From: Bob Neville
Sent: 03 February 2021 11:22
To: DC Support
Subject: FW: Planning notification for application reference: 21/00026/F
Attachments: eCon_(2).pdf

I am commenting on the above application from an arboricultural aspect.

Proposal – to build a new dwelling in rear garden of 13 Blackwood Place, Bodicote

TRR - 'Section 3'

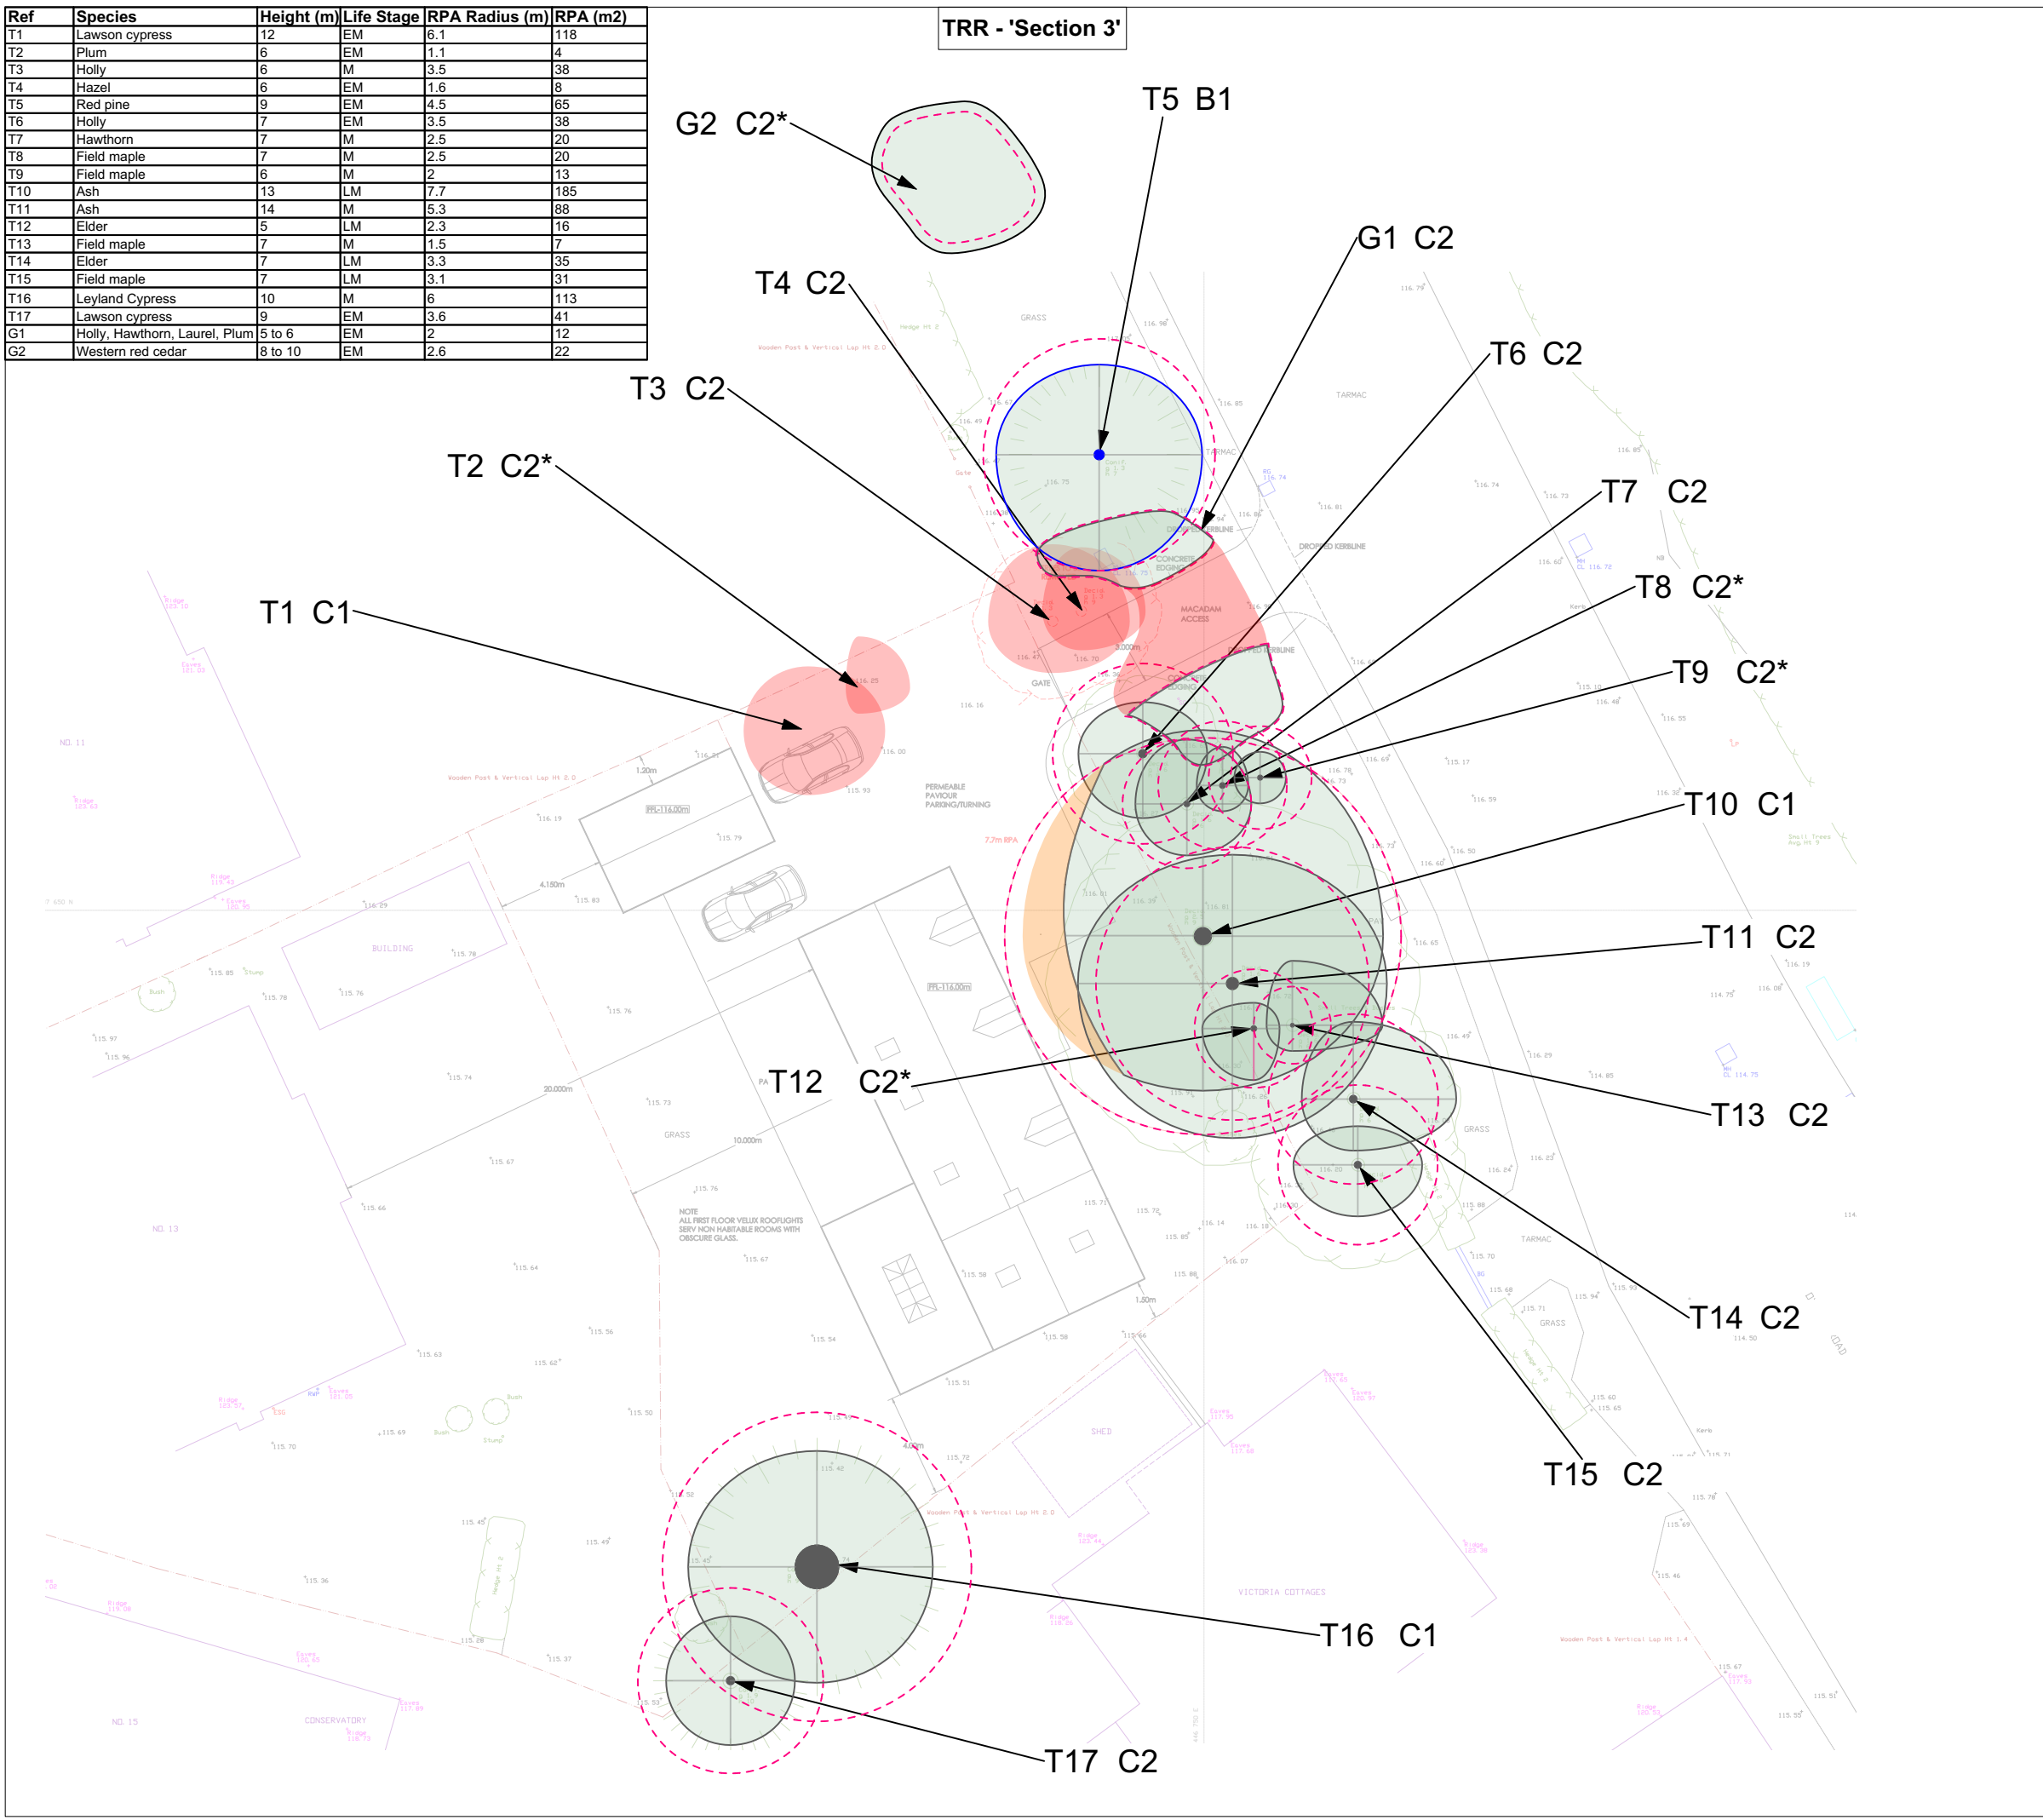
- There are no retained trees impacted significantly by the proposed new build.
- However the access and hard landscape does have an impact on both on and off site trees. The two on site trees are T1 and T2, which are C category conifer and plum trees.
- The 2 external trees to be removed are also C category holly and hazel trees along with part of group 1. As these are Highway trees it is a matter for the County Highways to allow these trees to be removed.
- If approved a condition will be required for a detailed Arboricultural Method Statement.
